Ref – Planning Application R/64/17/PL for Demolition of 1 No. dwelling & erection of 4 no. dwellings, at St. Mary's Close, Hurst Road, Rustington.

We would like to register our **objection** to the proposed development of St Mary's Close for the following reasons:

<u>SCALE</u>	<u>DATE</u>	<u>BY</u>
1:200	21-12-2016	PD
<u>NUMBER</u>	<u>SHEET</u>	<u>REV'N</u>
P1017	1	-

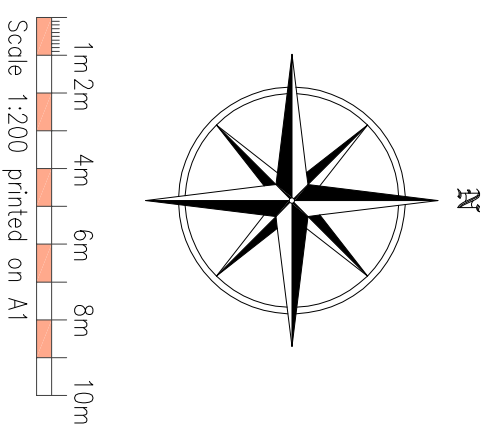
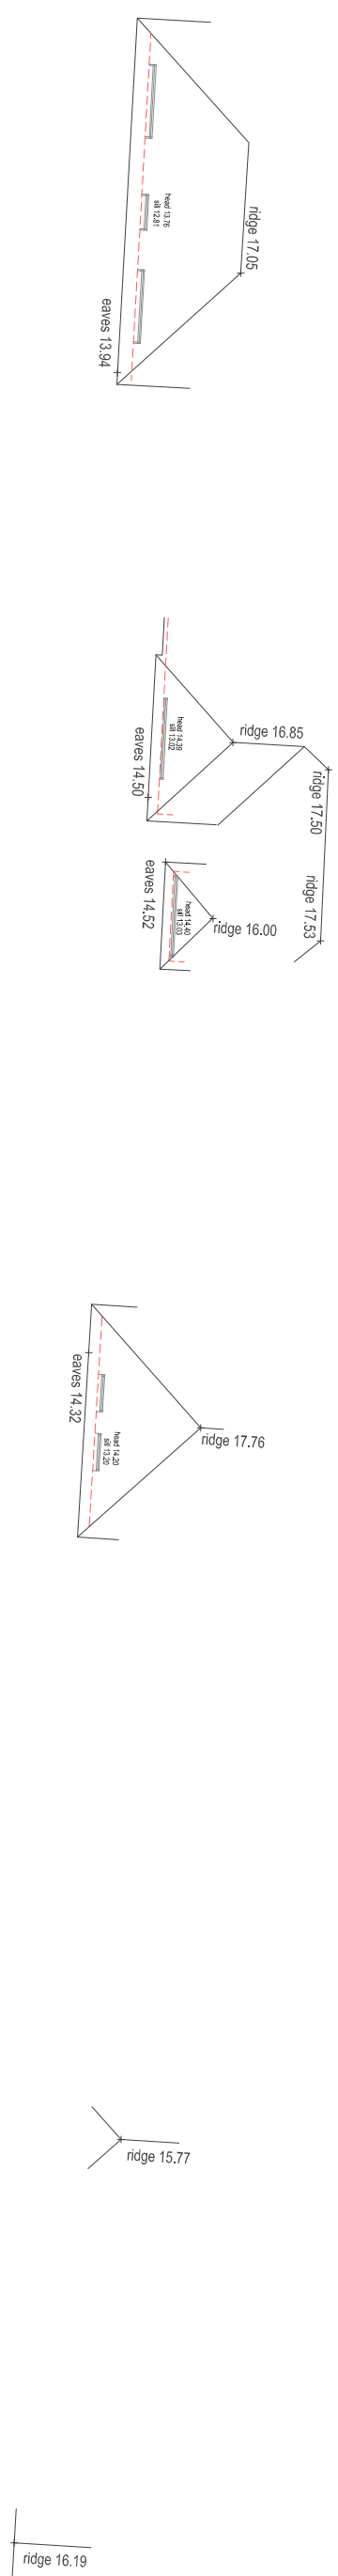
- In several places, the letter refers to the '*retention of the existing building line*' but clearly this isn't correct as demonstrated previously;
- The Landscaping and Trees sections talks about preserving trees and states that '*all existing trees in the rear garden will be retained*'. The Site Survey Plan drawing ref P1017 shows several trees and hedges that will clearly have to be removed during the construction phase;

Drg No: 151117_SS-01 Rev: D

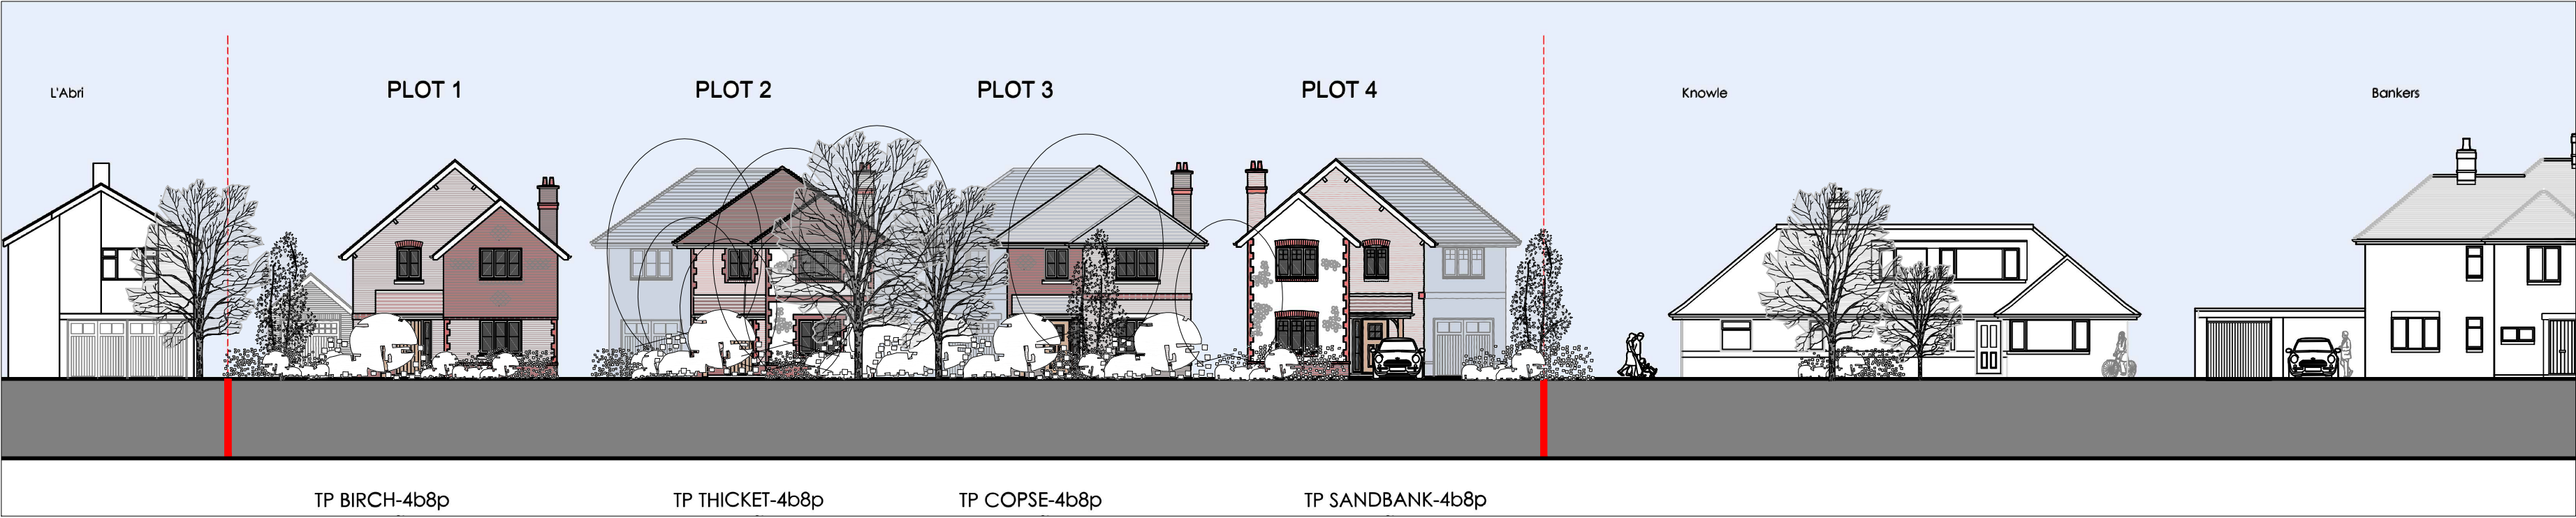
The detached garage blocks / car ports partially obstruct the view of the houses with Plot 4 having the appearance that it is accessed through the car port. This will completely ruin the street scene and fails to meet the criteria of the Local Plan D SP1 Design 13.2.2 which states *'the successful introduction of*

- There is a significant lack of dimensions leaving the development wide open to change if implemented;
- The architect has cleverly shaded out the rear portions of plots 2 and 3 to create an optical illusion of space between the properties;
- There appear to be several inconsistencies between the plans and elevations which again create the illusion of space. The following two extracts demonstrate how the spacing between plots 2 and 3 vary between the drawings, with the plan showing approx 2m and the elevation showing as little as 600mm between the eaves (measurements scaled as none provided on drawings);
